**Planning & Building Control Service
Development Management
Westgate Plaza
PO Box 603, Barnsley, S70 9FE
Head of Service: Joe Jenkinson**

My Ref: 2021/1089 and 2021/1090
Your Ref:
Date: 21st January 2022
Enquiries Stacey White
Direct Dial: 01226 772604
E-Mail: staceywhite@barnsley.gov.uk

PLANNING APPLICATIONS: 2021/1089 & 2021/1090
LOCATION: MU1 site, Land South of Barugh Green Road, Barnsley

B6131 DARTON LANE

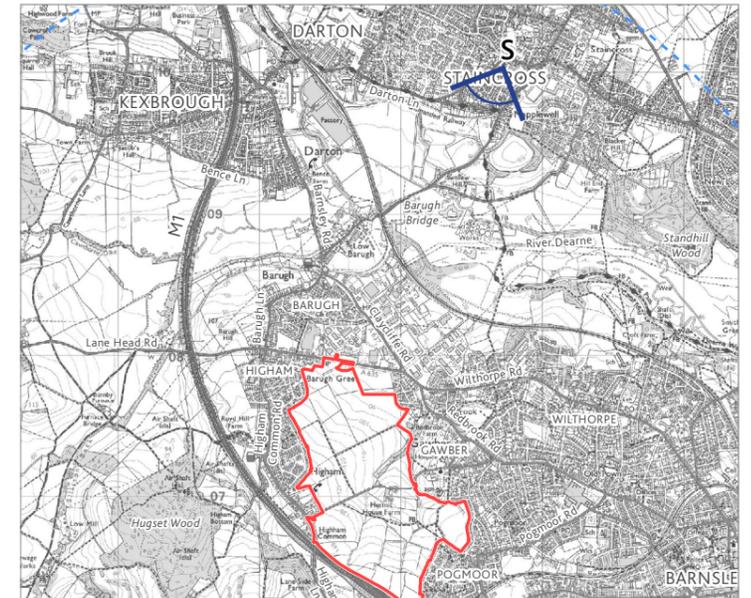
Xanthe has identified several issues with the assessment conclusions in terms of impacts on views into the site from near-middle distance which are considered to be transformative. Extensive middle-distance views from Mapplewell are not considered for example from Darton Lane, Swallow Hill Road, B6428, Hill End Road and Lidgett Road. Employment development will be 'perched' in the landscape across views and of considerable scale. The effects of the development from the motorway is also considered to be underassessed.
